RE: Mixed Use Student Accommodation Development at 60-78 Regent Street, Redfern, SSD 14_6724

Please find attached a table summarising the City's review of the Response to Submissions. The table nominates the issues raised within the City's original submission, discusses the Proponent's response to the issues raised and outlines the City's sustained contention in relation to the project.

Reconciliation of Issues

RE: Mixed Use Student Accommodation Development at 60-78 Regent Street, Redfern, SSD 14_6724

LANDSCAPE PLAN - GROUND FLOOR

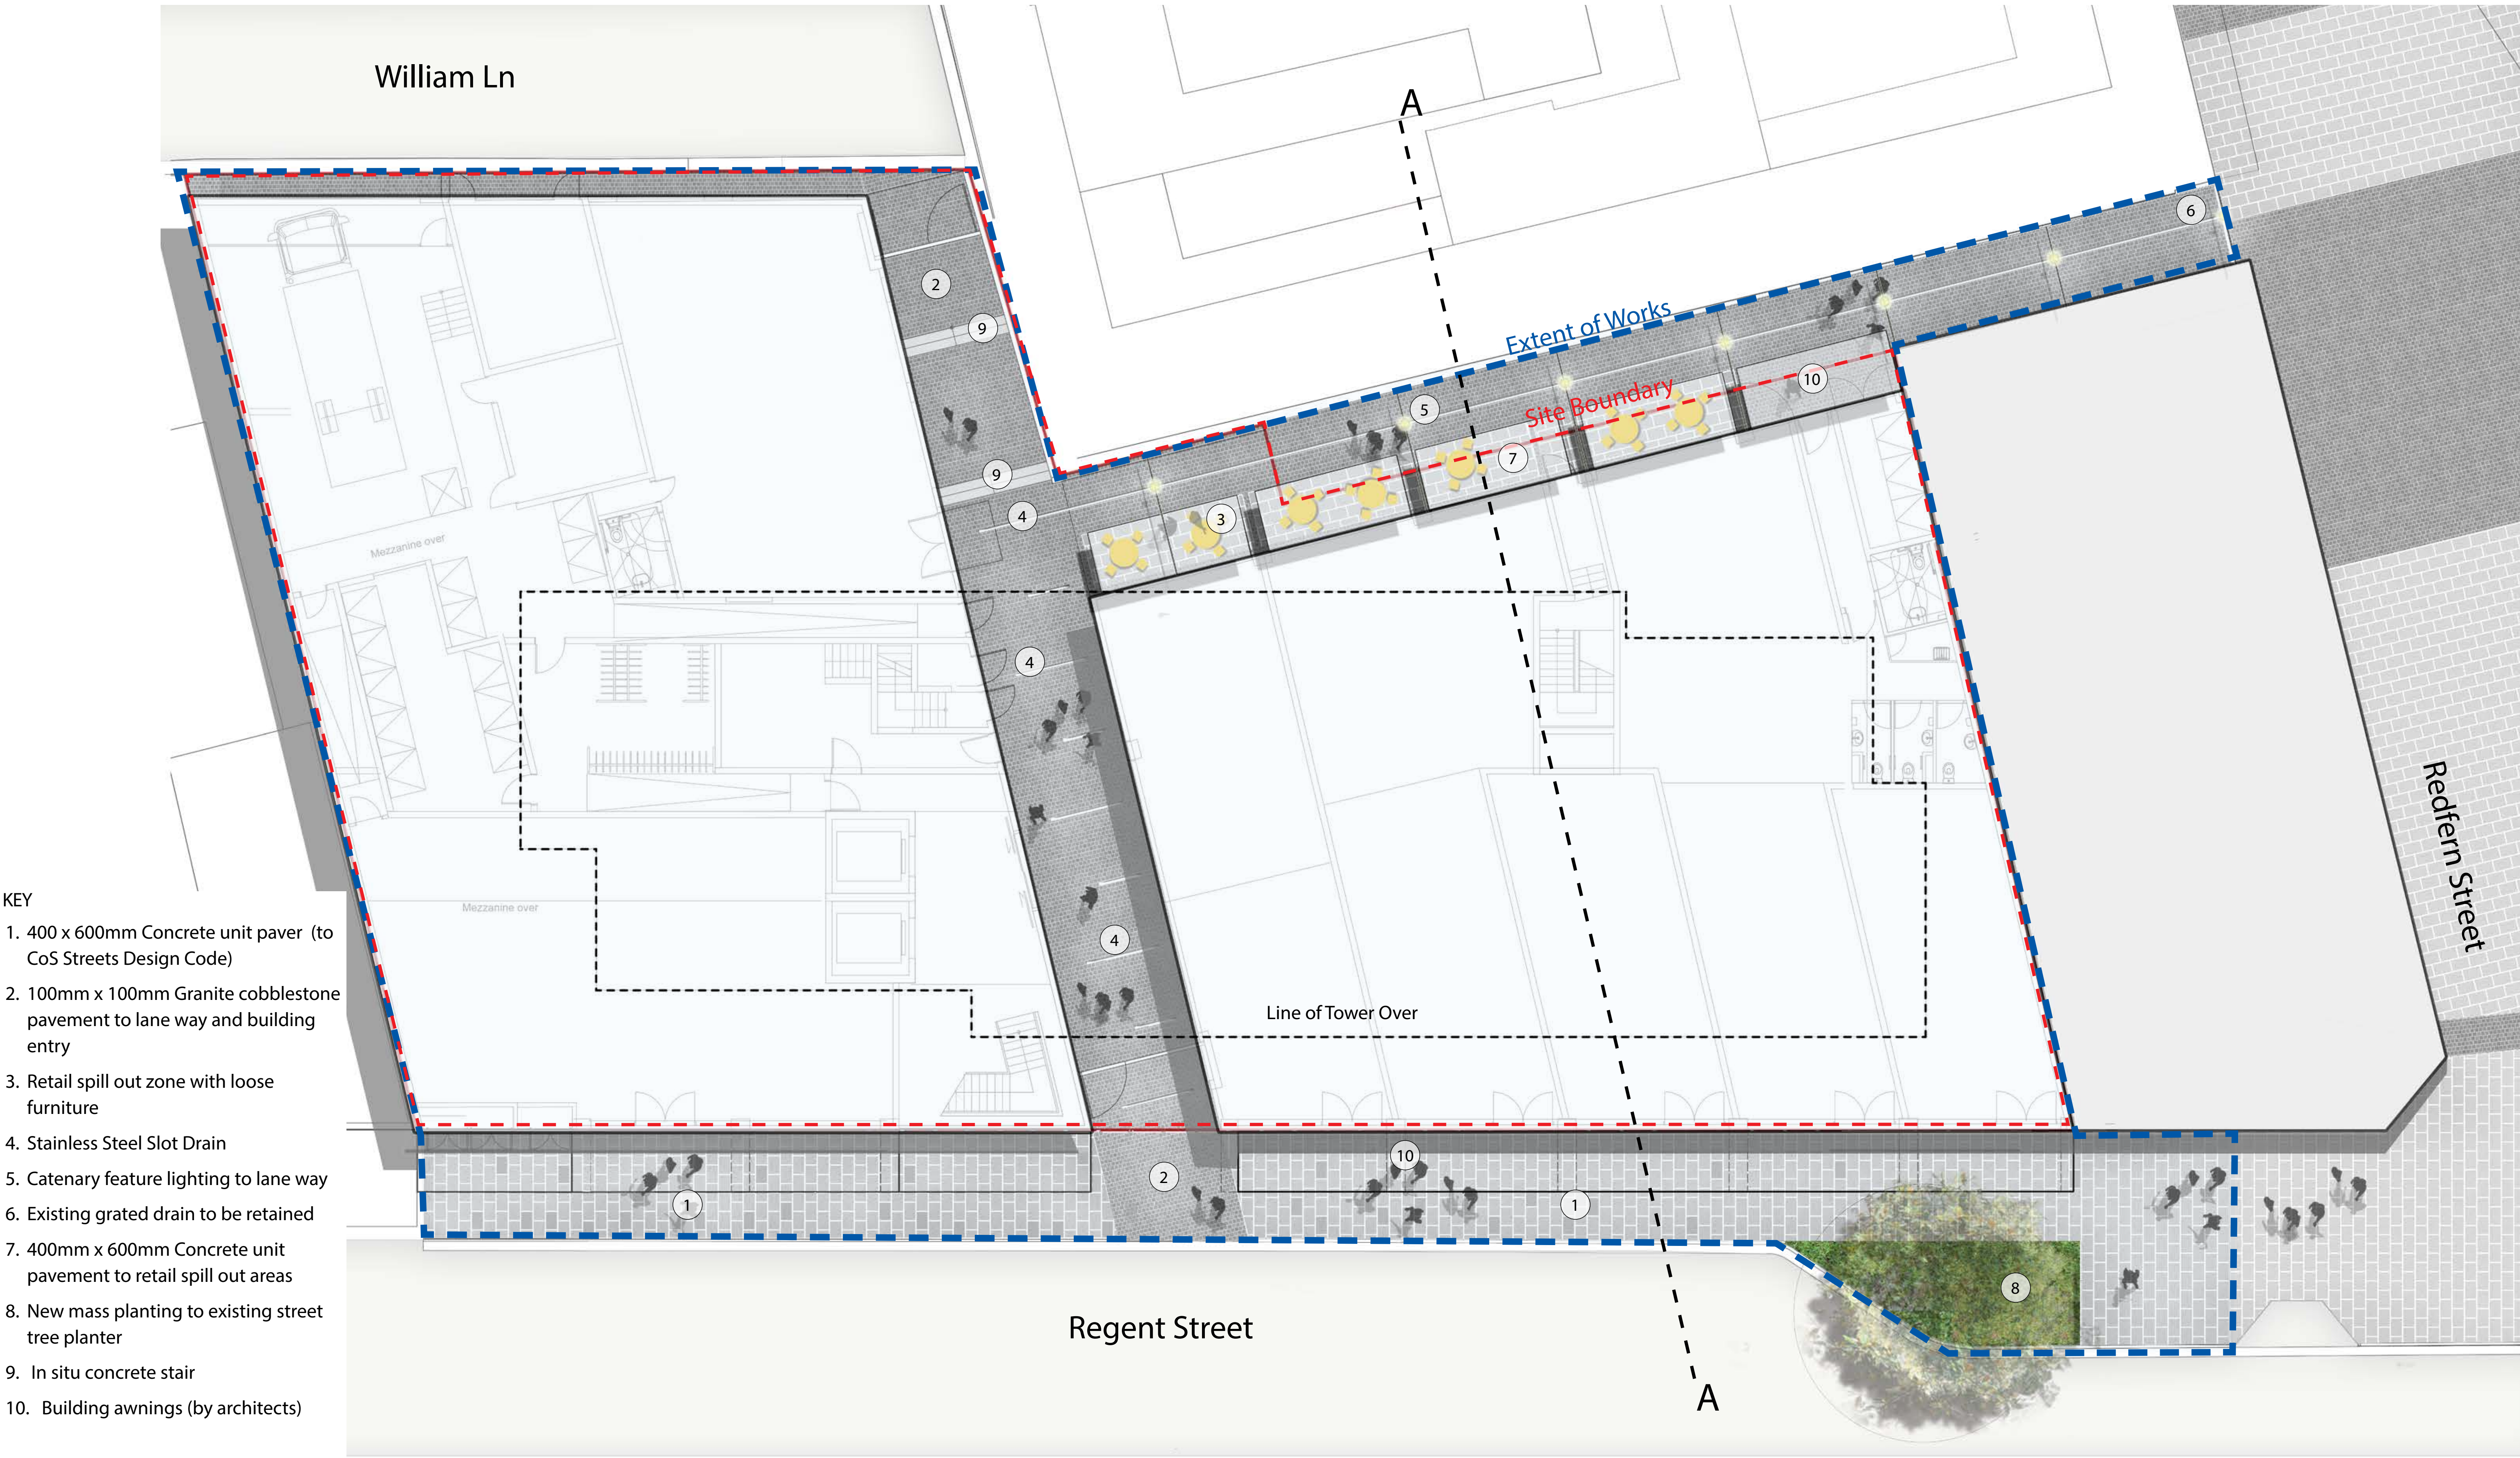
It is noted that no deep soil zone is provided on site. Given the constraints of the site, its urban location and the positioning of the common space on the Level 1 podium, this is considered to be acceptable. An appropriate landscape management plan should be put in place to ensure the ongoing maintenance of soft landscaping on the Level 1 common open space.

Active uses are encouraged along the laneway to promote pedestrian use. Lighting appropriate to the scale of the space as well as signage should be designed to allow easy identification by users. Detailed design of the laneway will need to consider design elements which clearly delineate between public and private spaces especially in the loading dock area.
